# KITTITAS COUNTY DEPARTMENT OF PUBLIC WORKS

## MEMORANDUM

TO: Mike Elkins, Community Development Services  
FROM: Christina Wollman, Planner II *CW*  
DATE: October 2, 2007  
SUBJECT: Calvin Stanford Short Plat

DRAWN BY: MMJ
CHECKED BY: D.S.G.
PROJECT NO. 06216
SHEET 1 OF 2

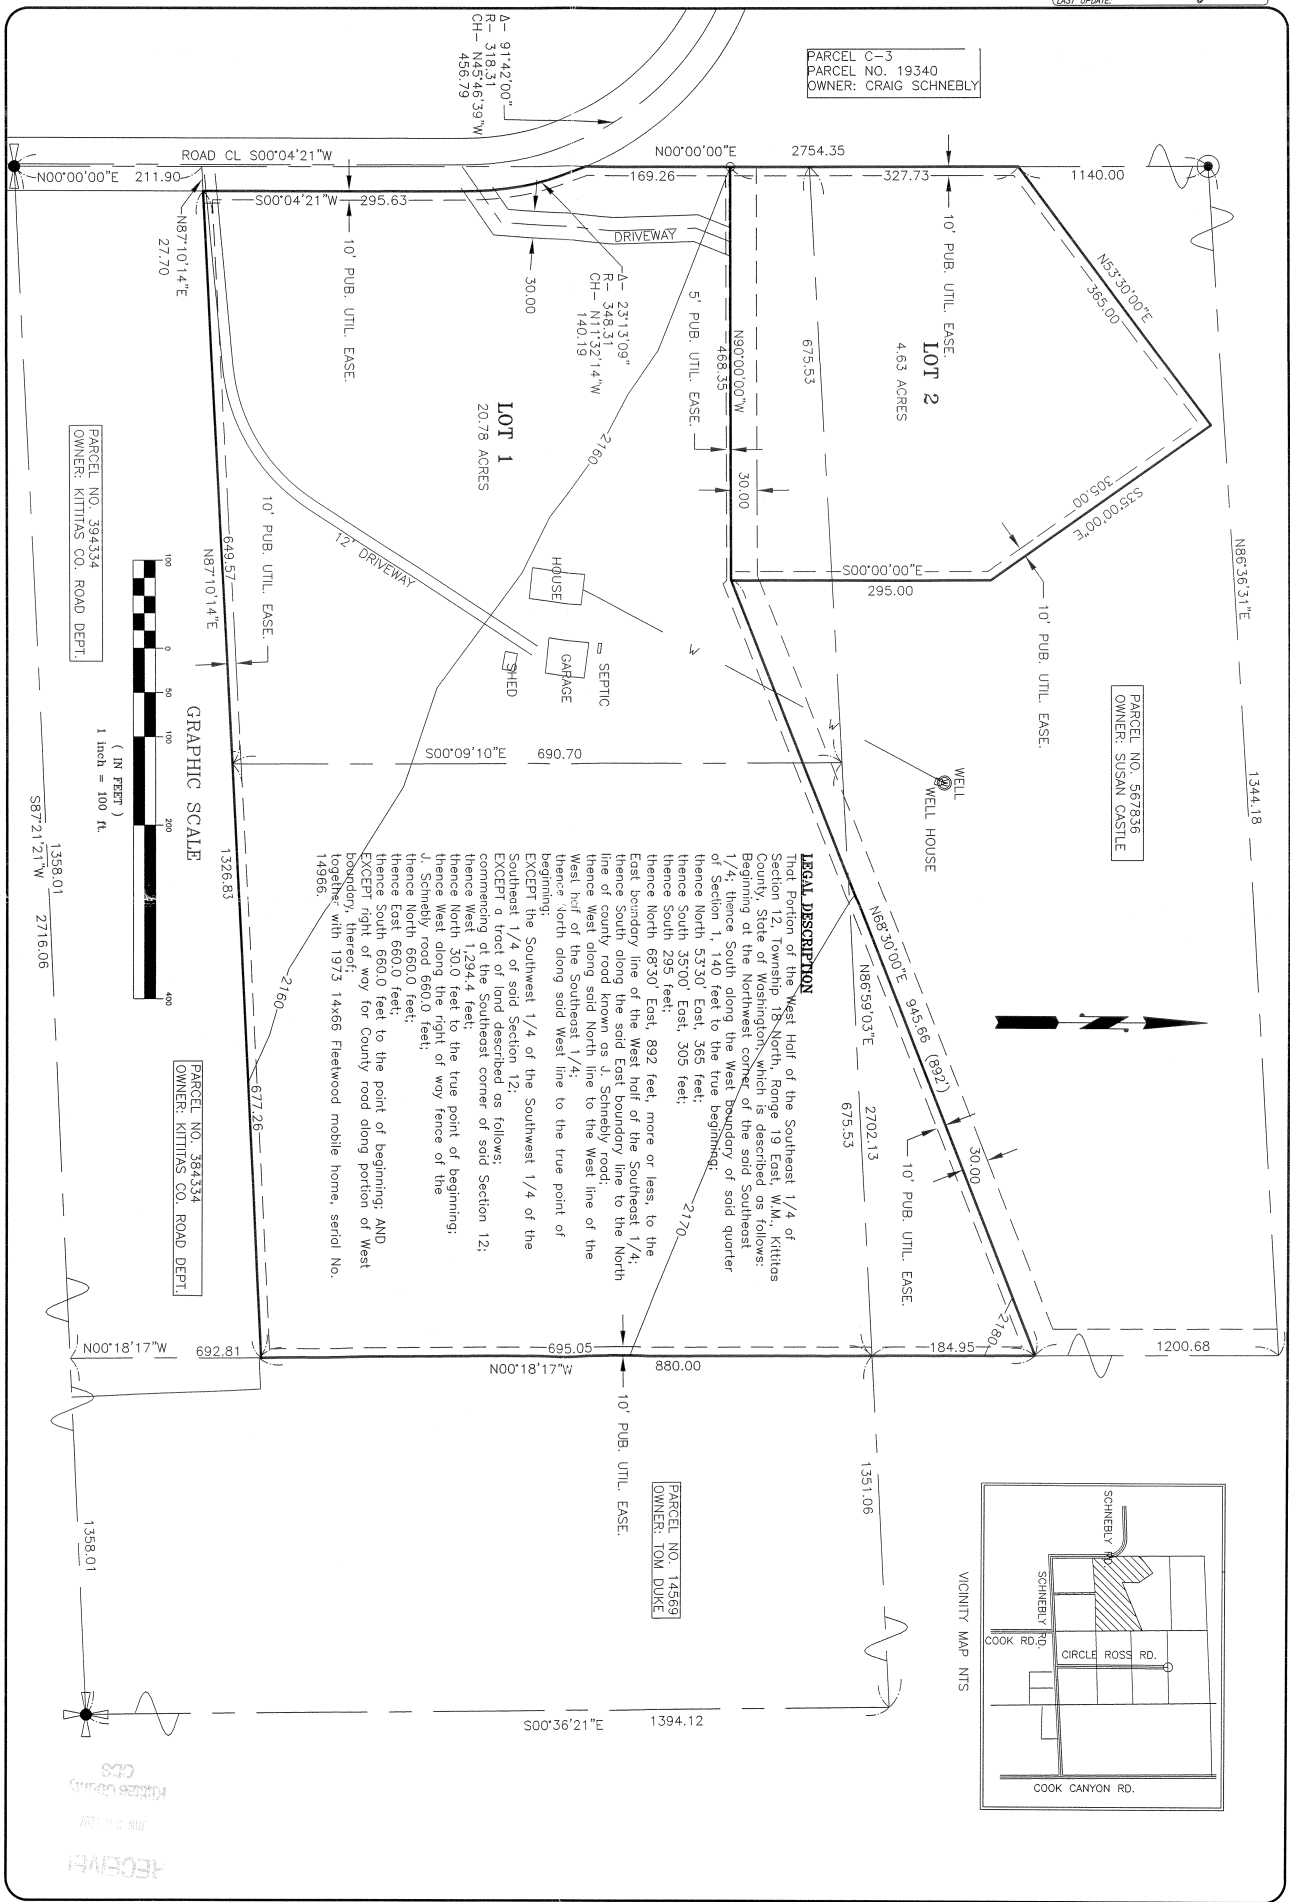
2. Lot 2 Access: Lot 2 is accessed through an existing driveway on Lot 1. An easement shall be established across Lot 1 for the benefit of Lot 2. The easement shall be 60' in width to meet the private road requirements listed below. The easement should also consider access to the two lots to the north that access across Lot 1.

3. Private Road Approach Design: The approach for the road leading to Lot 2 shall be designed in accordance with Figure 920-3 of the WSDOT Design Manual. The approach must extend perpendicular from the County road shoulder for at least 20'.

4. Cul-de-Sac: An emergency turnaround is required for all roads serving three or more lots. A cul-de-sac (permanent or temporary) is required on Lot 2. A hammerhead may be constructed with the approval of the Fire Marshall. Additional easement will be required depending on the type of turnaround constructed. See Kittitas County Road Standards, 9/6/05 edition.
